# ENG-SF21032-R1-GEC.pdf Markup Summary

**Subject:**  
**Page Index:** 1  
**Date:** 11/22/2021 10:51:25 AM  
**Author:** dsdrice  
**Color:**   
**Layer:**  
**Space:**  
**Page Label:** [1] 1 Cover Sheet - CV01

**Subject:** Contractor  
**Page Index:** 2  
**Date:** 10/26/2021 5:27:53 PM  
**Author:** EPC Stormwater - Glenn Reese  
**Color:**   
**Layer:**  
**Space:**  
**Page Label:** [3] 3 Phase 2 GESC - GESC (2)

STERLING RANCH FILING 3
COVER SHEET
SHEET 1 OF 7
JOB NO. 25188.00

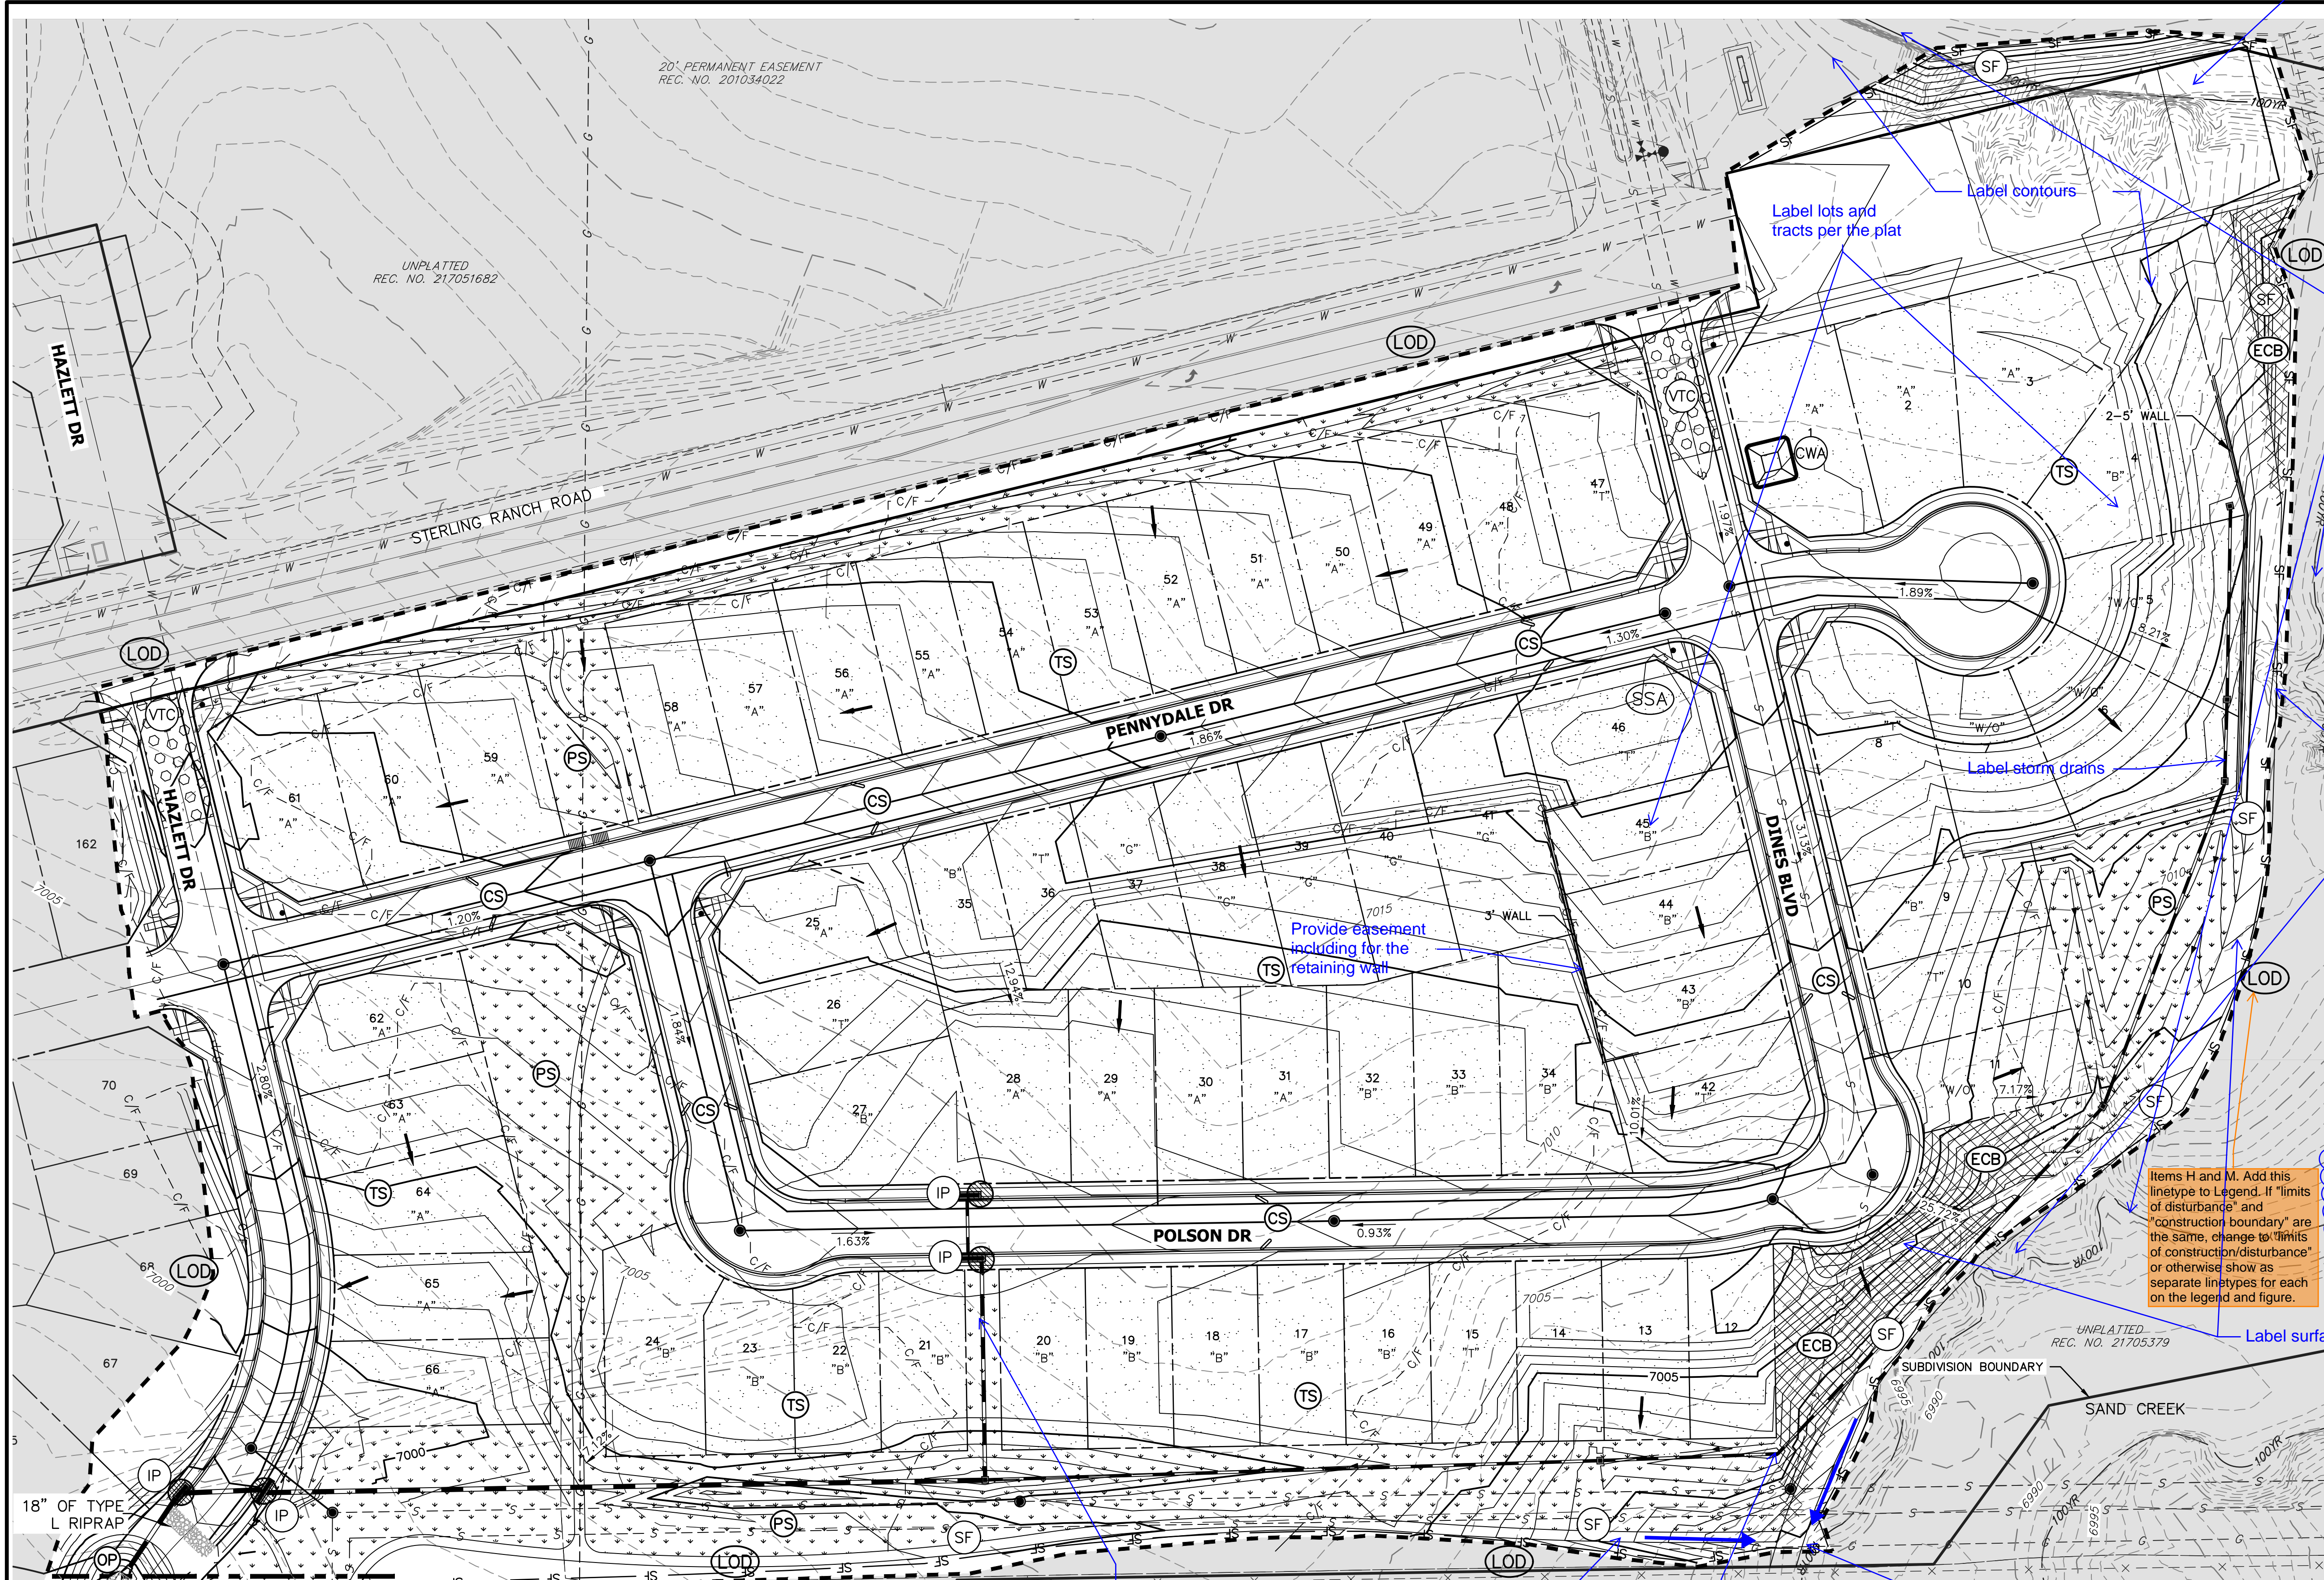
ENGINEERING INC. ON JUNE 25, 2020 AND SHALL  
CONSTRUCTION FOR PROJECTS THAT WILL DISTURB OR  
A PERMIT APPLICATION FOR STORMWATER DISCHARGE  
DIVISION. THE APPLICATION CONTAINS CERTIFICATE  
NO EROSION CONTROL PLAN MAY BE A PART. FOR  
update?

GRADING AND EROSION CONTROL PLAN

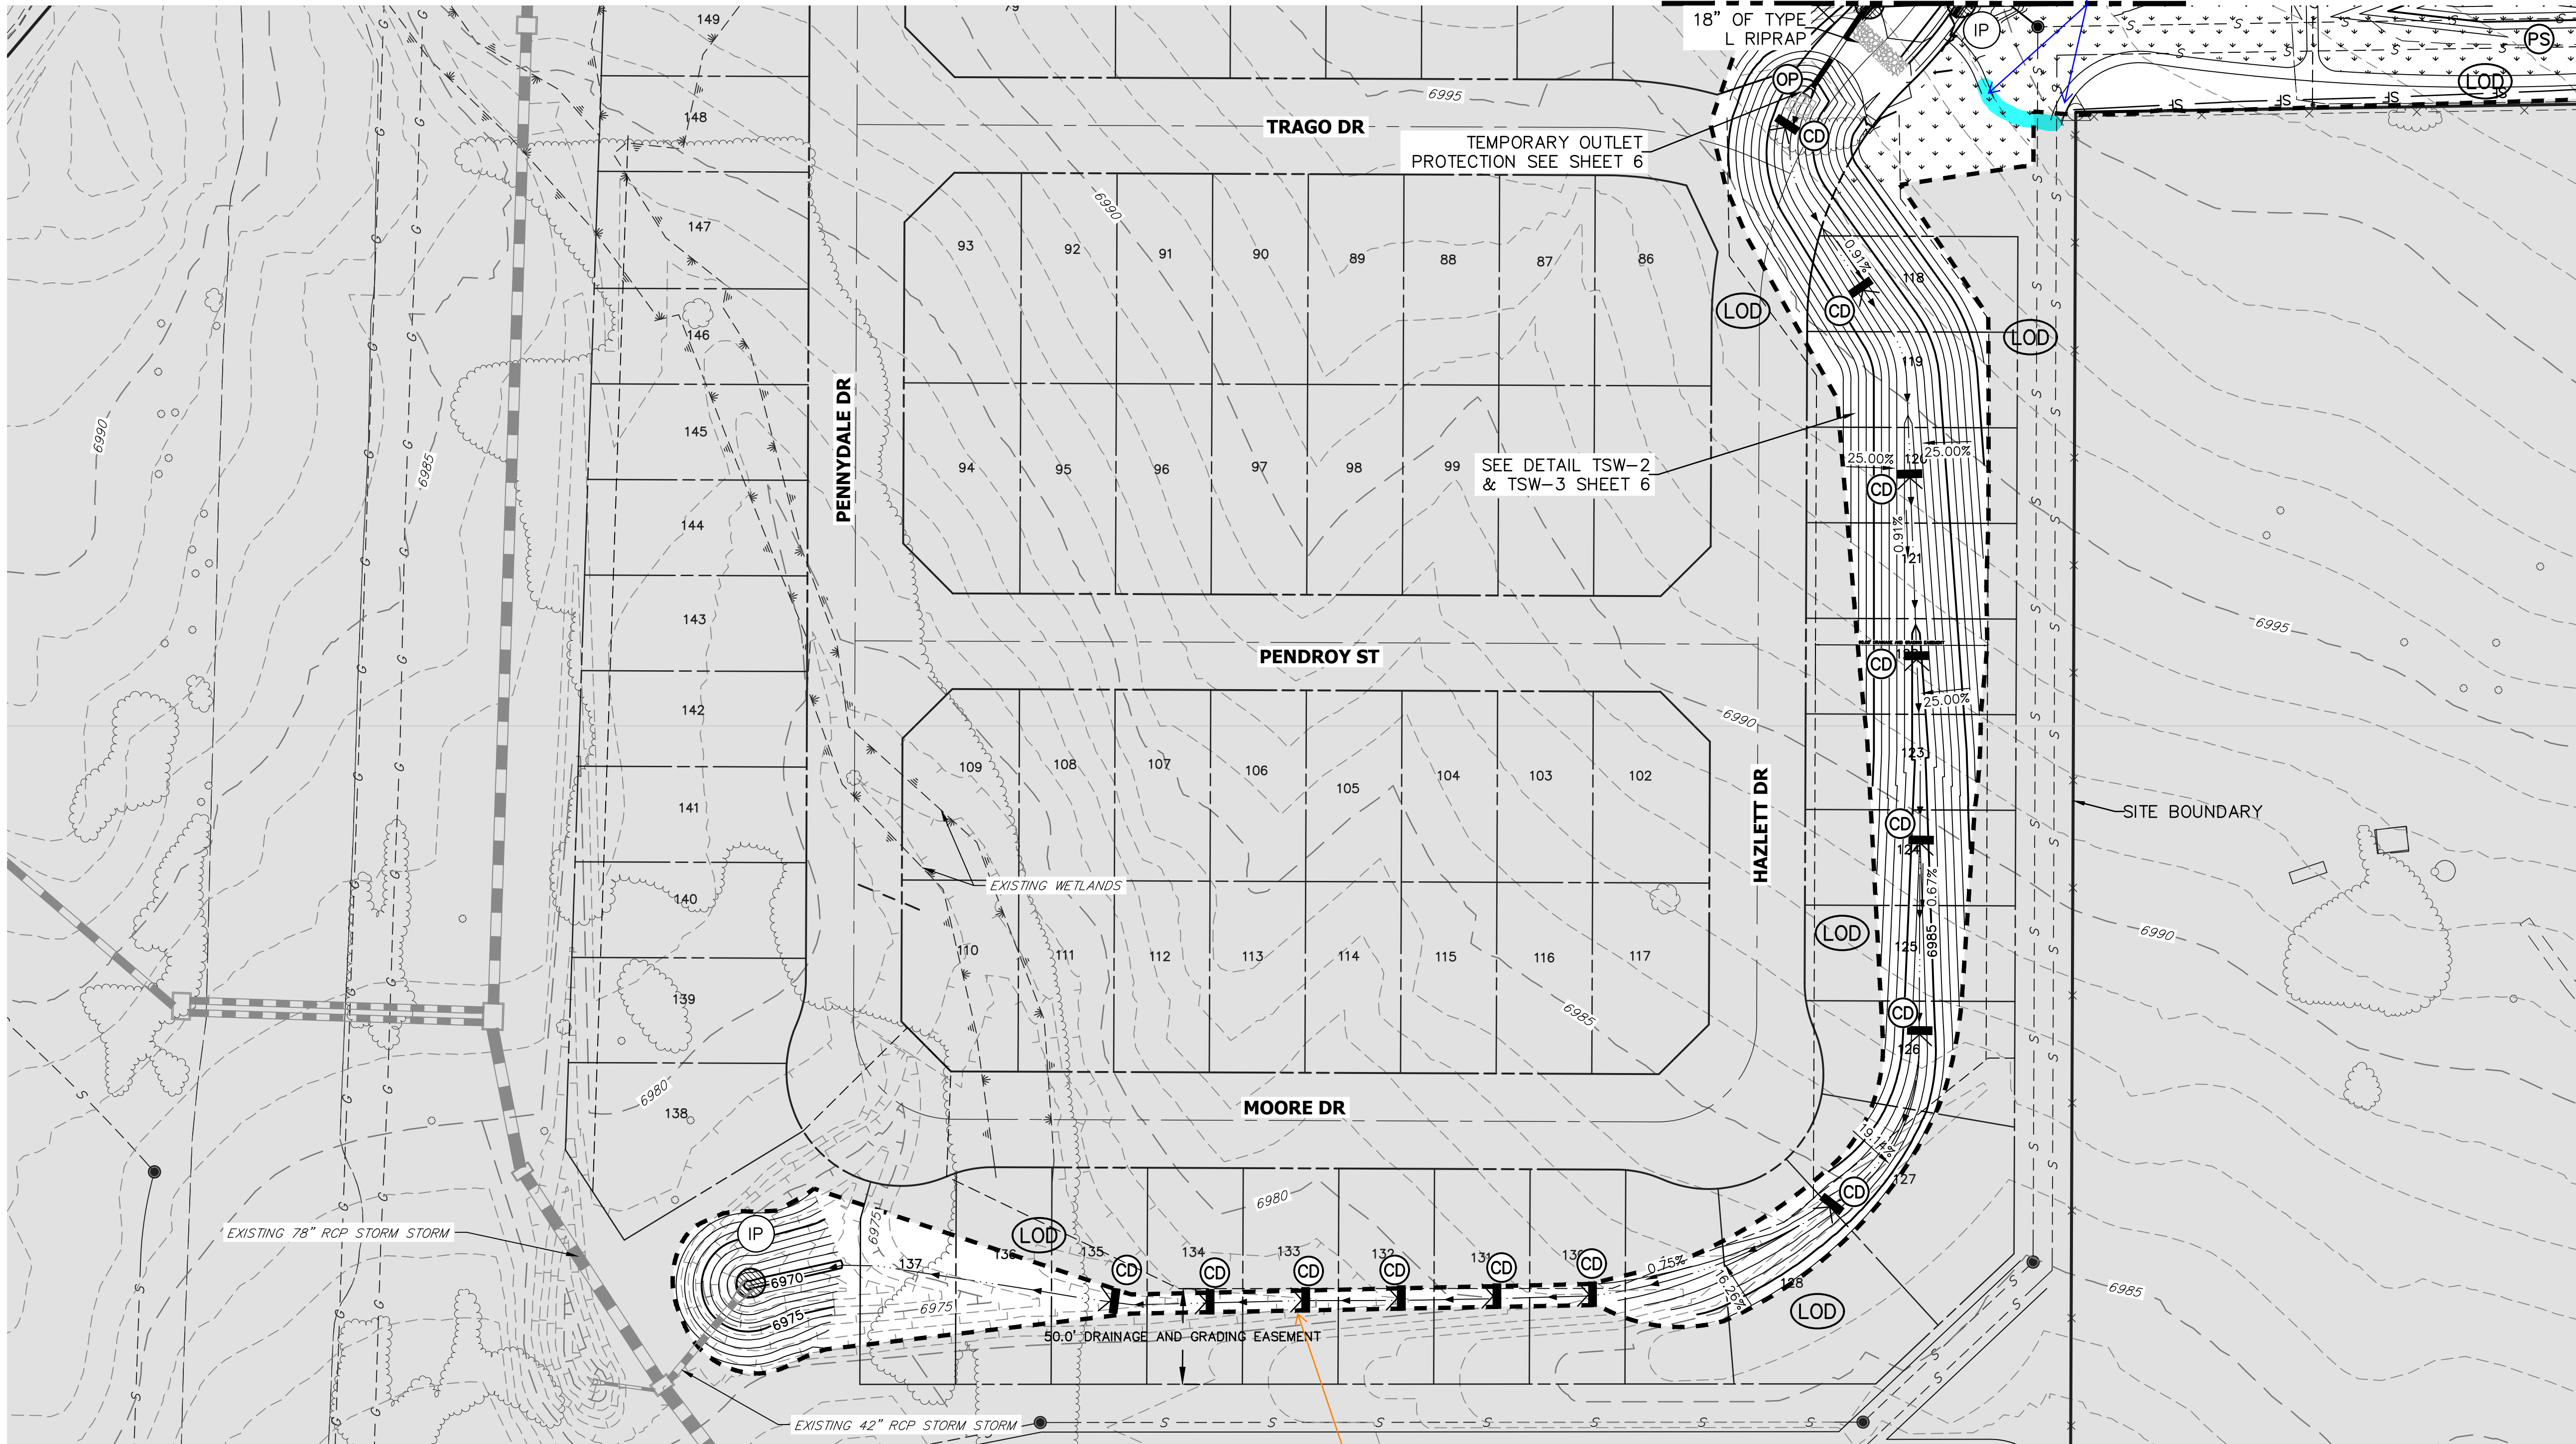
Items H and M. Add this linetype to Legend. If "limits of disturbance" and "construction boundary" are the same, change to "limits of construction/disturbance" or otherwise show as separate linetypes for each on the legend and figure.

inlet with protection?

label trail/access road

Label lots and tracts per the plat

Provide easement including for the retaining wall

Floodplain permitting requirements apply

Label contours

Label BFEs

Label storm drains

Label surfacing material

Show all grading necessary for the access road

Are these notes correct?

Provide bank stabilization/erosion protection

Provide swale grading in case of inlet overtopping to keep flow out of lots

Provide retaining wall details
